Application for a non-material amendment following a grant of planning permission.
Town and Country Planning Act 1990

Application No: 6/2015/2448/HOUSE; Date of Approval: 26 February 2016; Development: Erection of two storey, single storey rear extension and alterations At Location: 12 Rooks Hill, Welwyn Garden City, AL8 6ET; Applicant: Ms Lewis; Application Date: 10 December 2015

6. Non-Material Amendment(s) Sought

PROPOSED SIDE ELEVATION 1:100

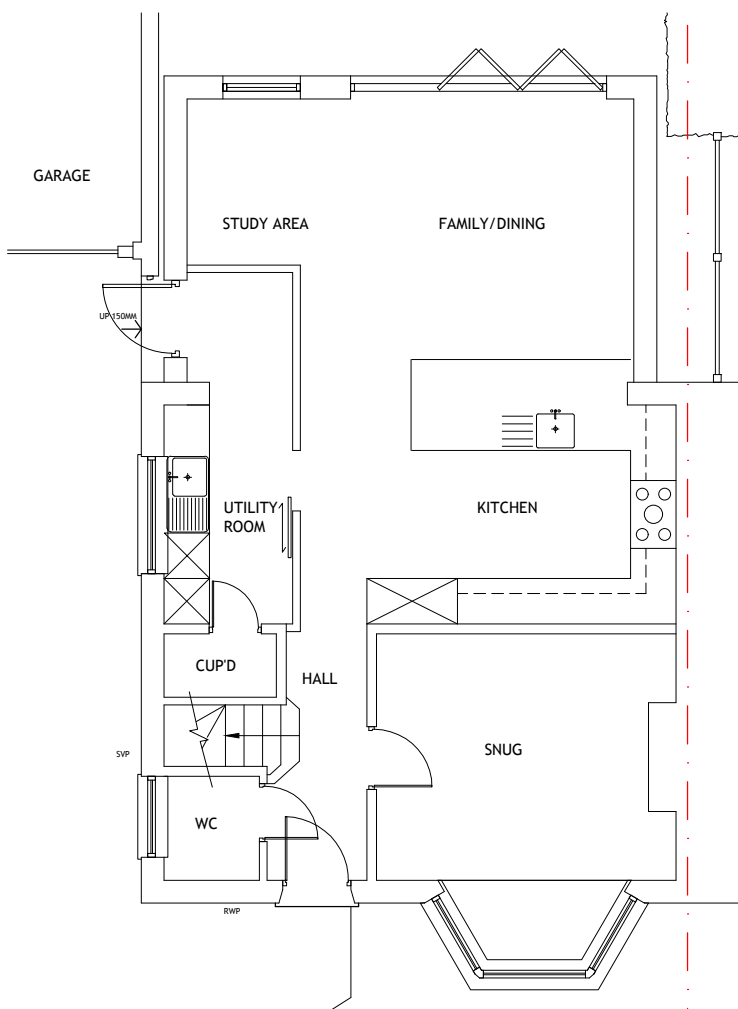
- 1) We would like to add another roof light onto the extension taking it from 2 to 3. One roof light will be above the ensuite and 2 above the bedroom (bedroom 3 on plans).
- 2) we would like to move the new window that was included in the original plans on the side elevation further to the left so that it lines up with the left of downstairs window

- 1) So that bedroom 3 has better symmetry and light
- 2) So that fitted wardrobe can be put in the dressing room and so that it looks neater from outside
